REQUEST

Current Zoning: MX-1(INNOV) (Mixed-Use District, Innovative), N1-A (Neighborhood 1-A), and IC-1 (Institutional Campus-1)
Proposed Zoning: MX-1(INNOV) SPA (Mixed-Use District, Innovative, Site Plan Amendment) and N1-D(CD) (Neighborhood 1-D, Conditional)

The petition proposes to develop a vacant site with up to 96 single family detached and/or single family attached dwellings.

The Drakeford Company

RZ-1

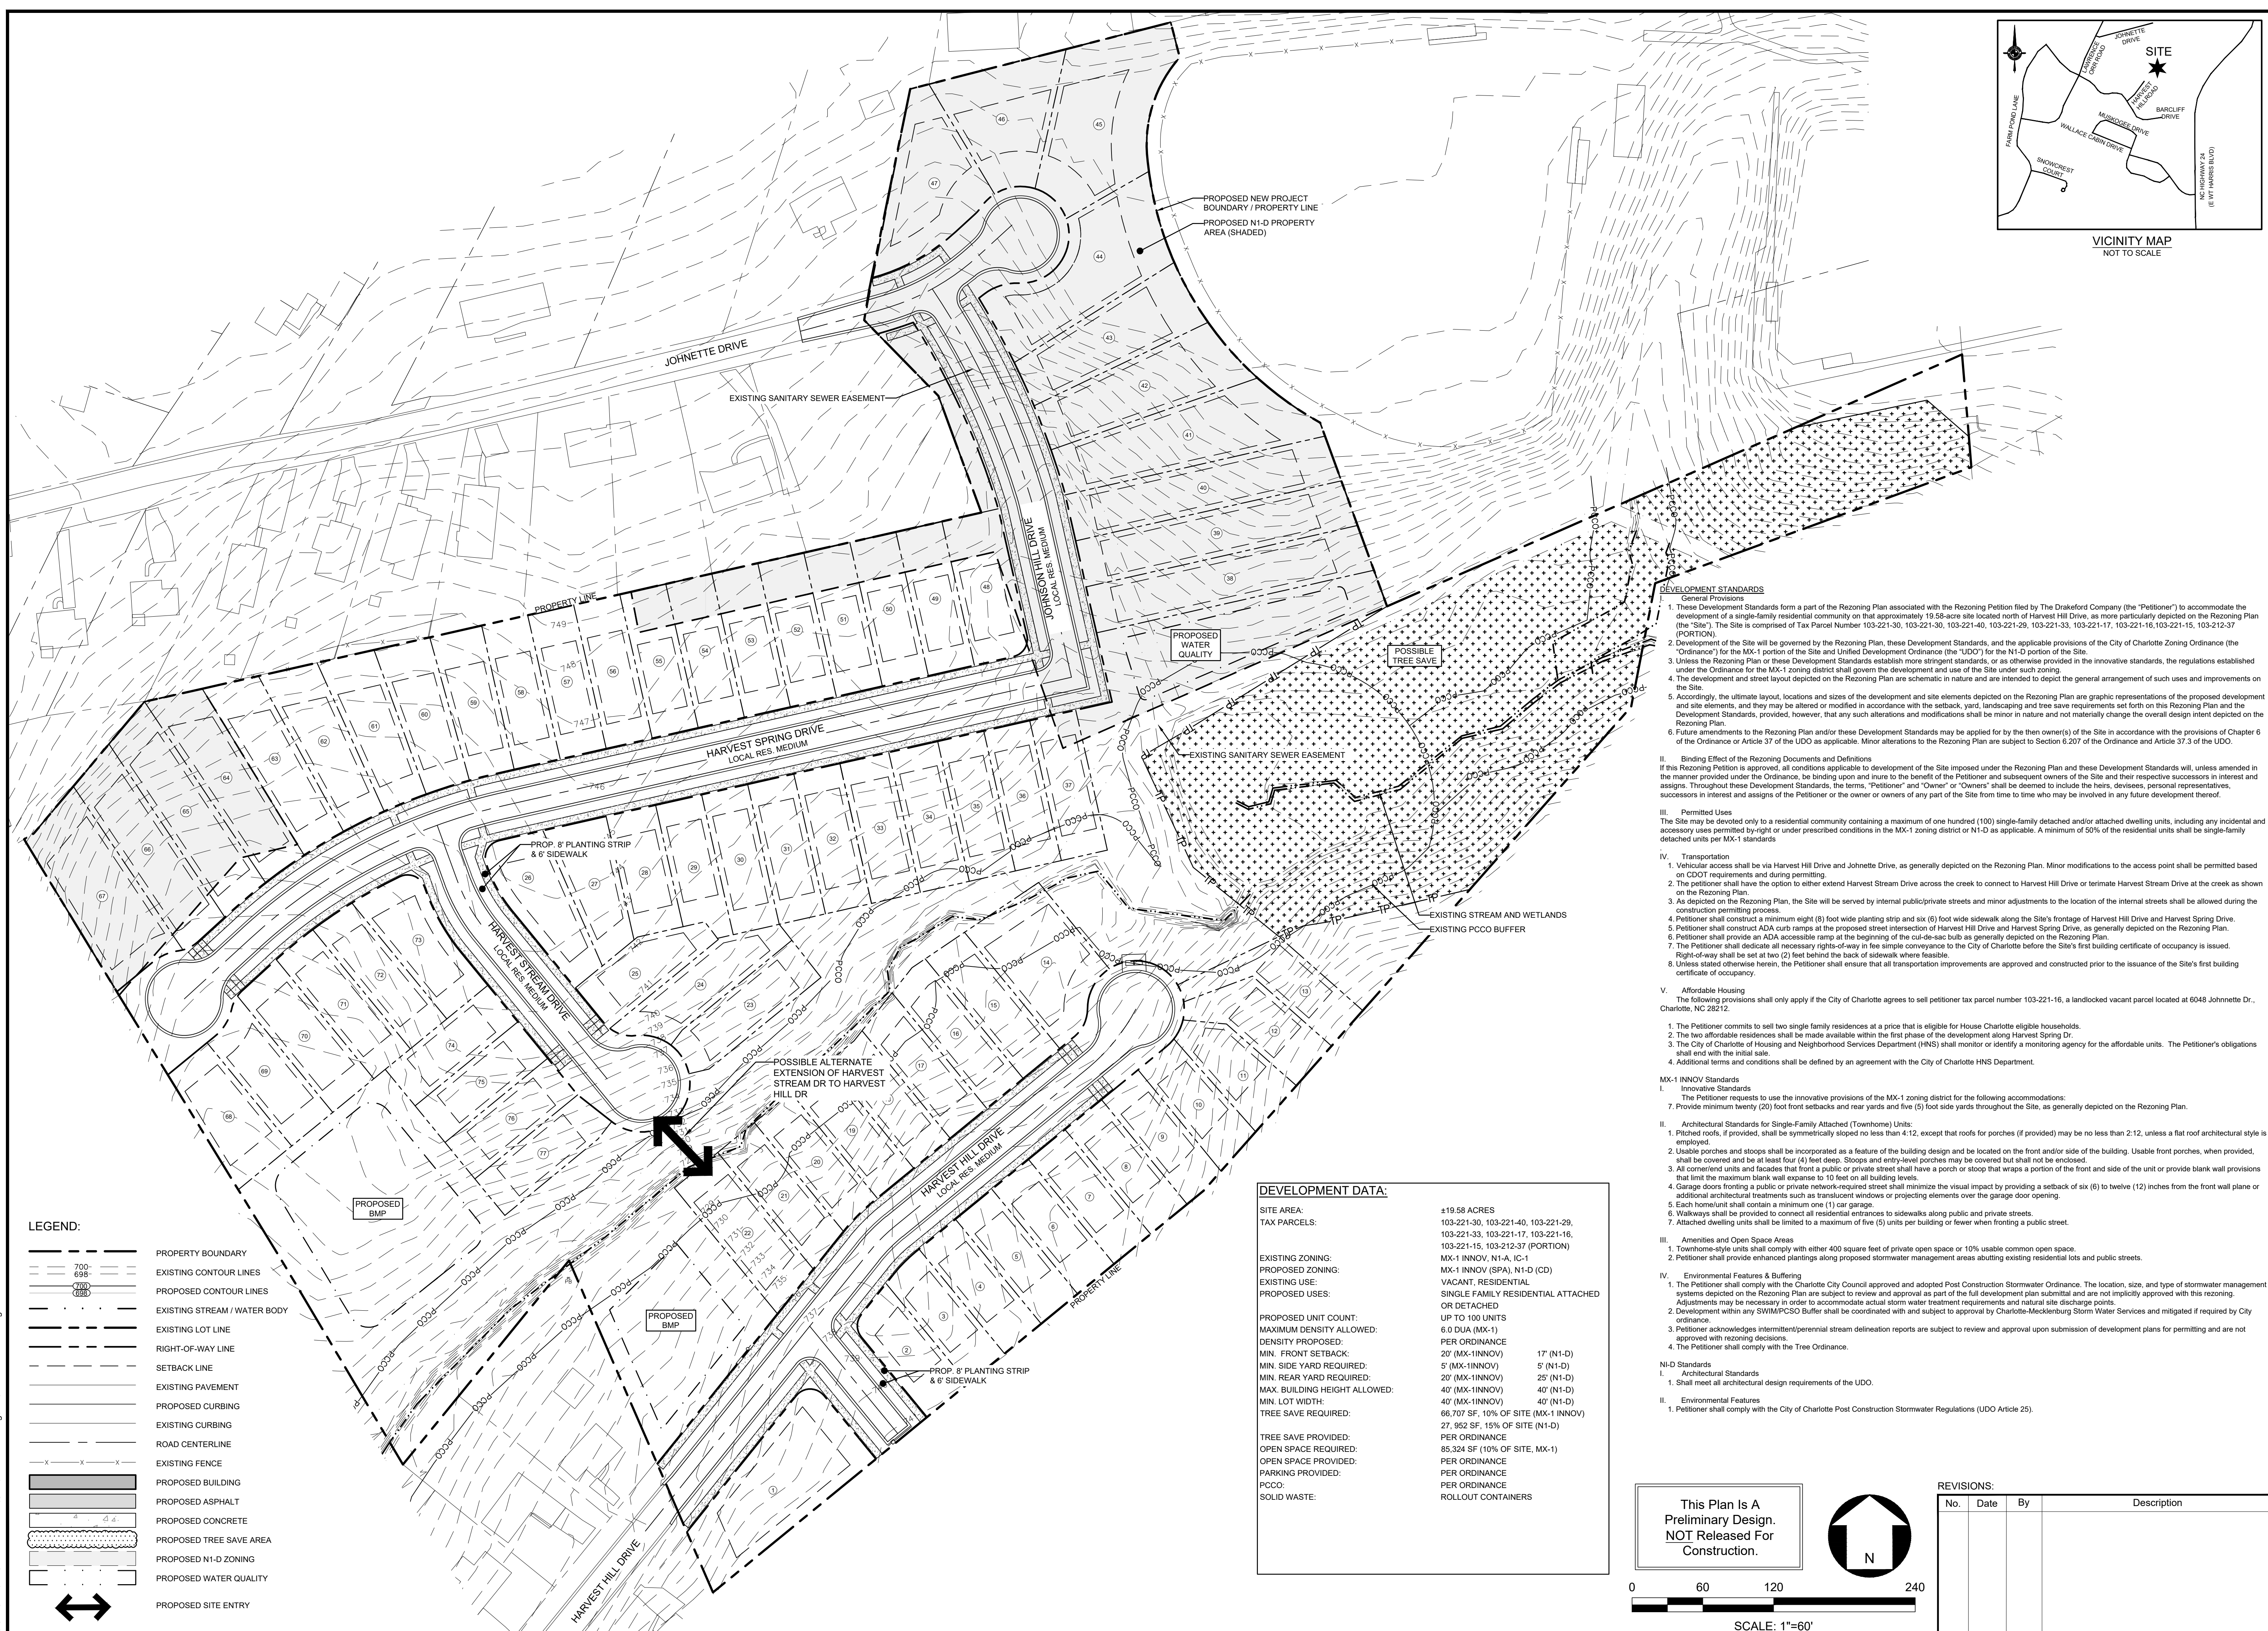
1. ~~Provide a conditional note stating that the proposed lots on Johnette Drive will be limited to single-family detached and/or duplex dwellings.~~ **ADDRESSED**
2. ~~Revise conditional note V.2 to state "Two units for affordable home ownership to be provided along Harvest Spring Dr. Affordable units must reflect the design and character of the units constructed within the development. Affordable units to be substantially complete before the first certificate of occupancy is issued for the development."~~ **ADDRESSED**

3. ~~Revise conditional note IV-3 to include Harvest Stream Drive. All internal new roads and road extensions shown on the site plan should be listed.~~ **ADDRESSED**

4. ~~Provide a tree survey identifying all city trees 8" DBH or greater and all planted city trees, all existing heritage trees, and any existing areas of the site used for credit toward meeting previously approved tree save or green area requirements.~~ ADDRESSED
-
